Please ask for: Nicola Moore
Email: nicola.moore@arun.gov.uk
Telephone: Ext 37944
Our Ref: BR/168/20/CLP
Your Ref:
Date: 29th July 2020

Lawful Development Certificate for a Proposed Use or Development

Development: Proposed ground floor rear extension, floor plan redesign and all associated works at 23 Wood Street
Location: 23 Wood Street Bognor Regis PO21 2PJ

Block Plans

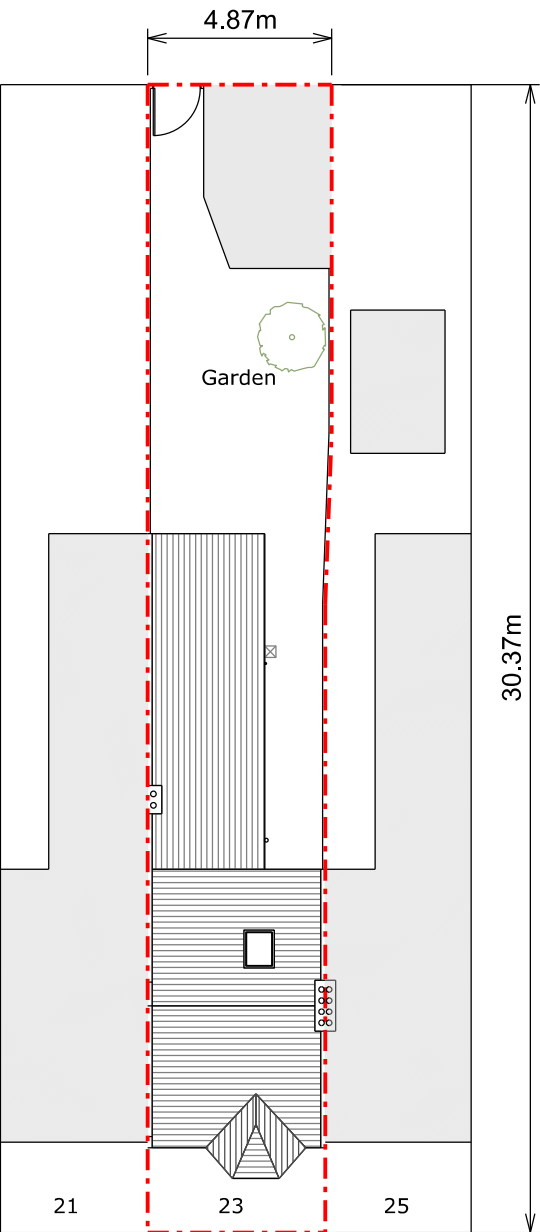
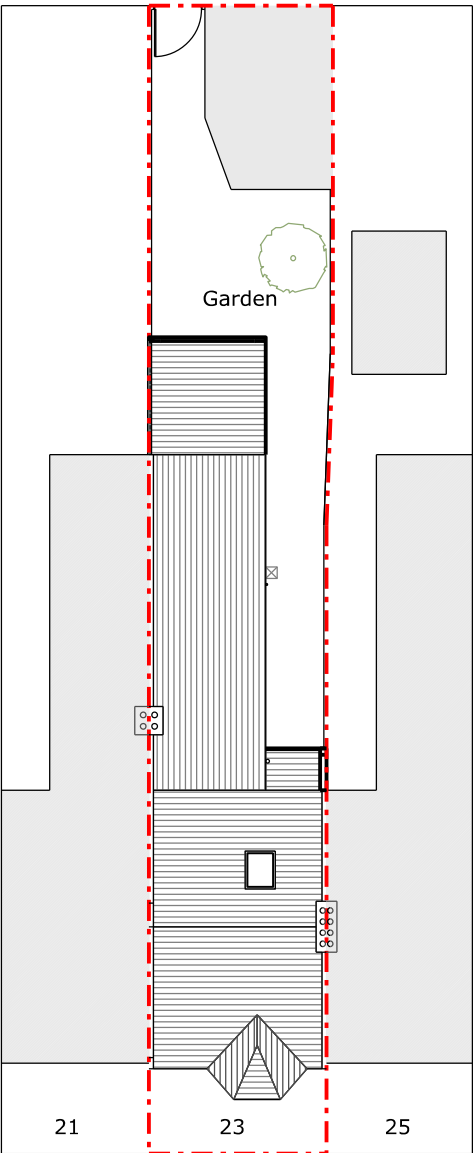
The Block Plan should include measurements to boundaries. Please amend and re submit.
Elevations

Existing Elevations

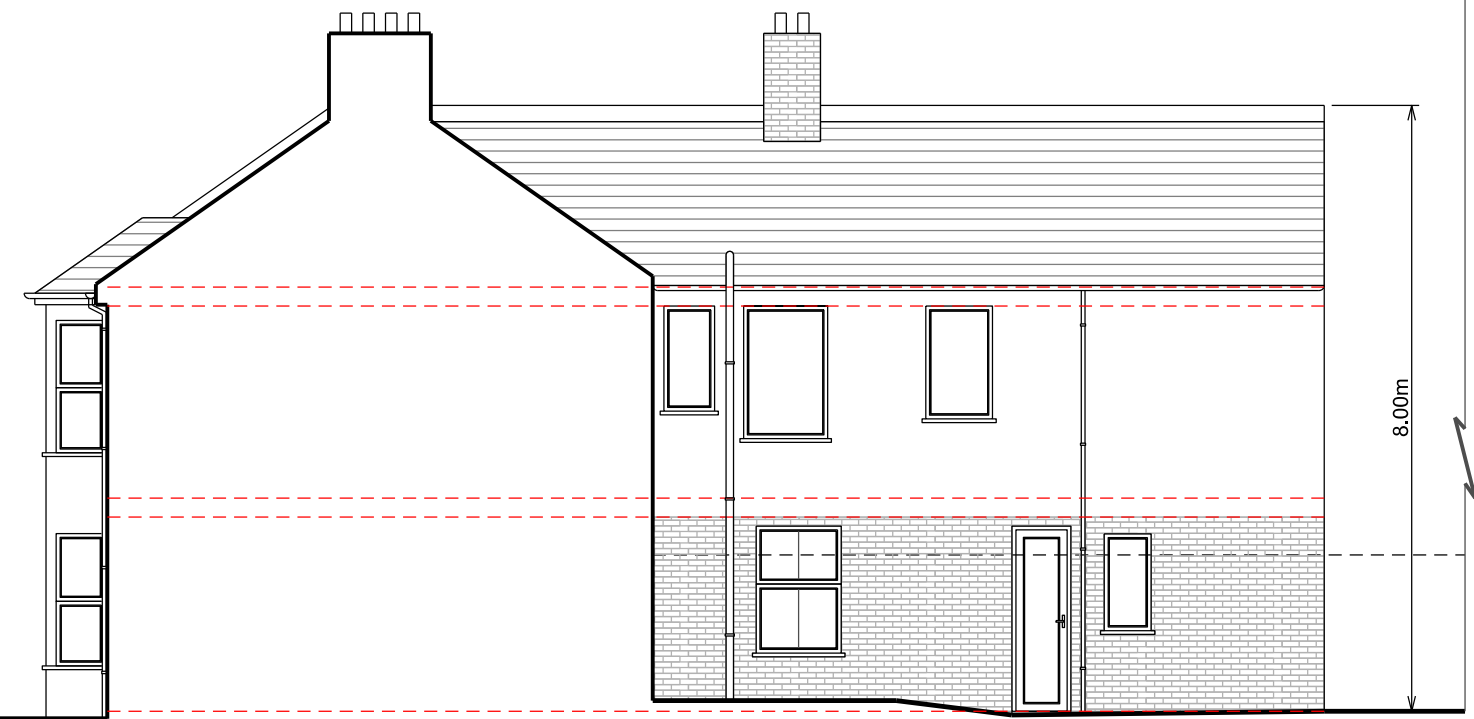
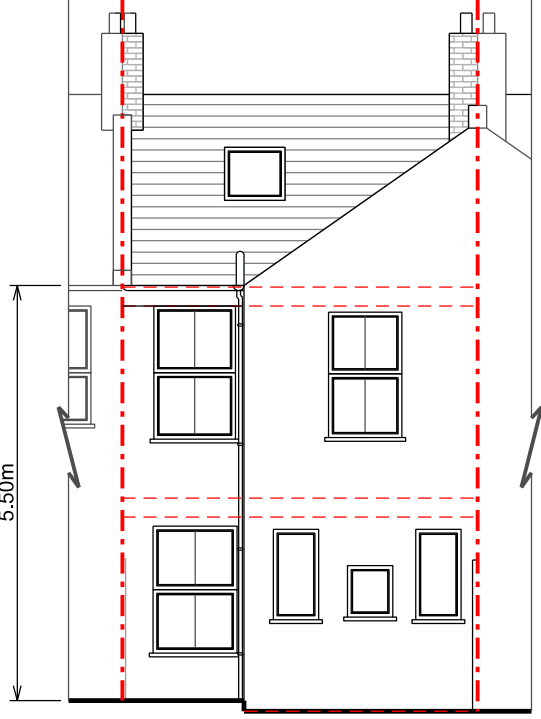
Please check the East and West existing and proposed elevations have been labelled correctly. Please either confirm if they are correct or amend accordingly and resubmit.
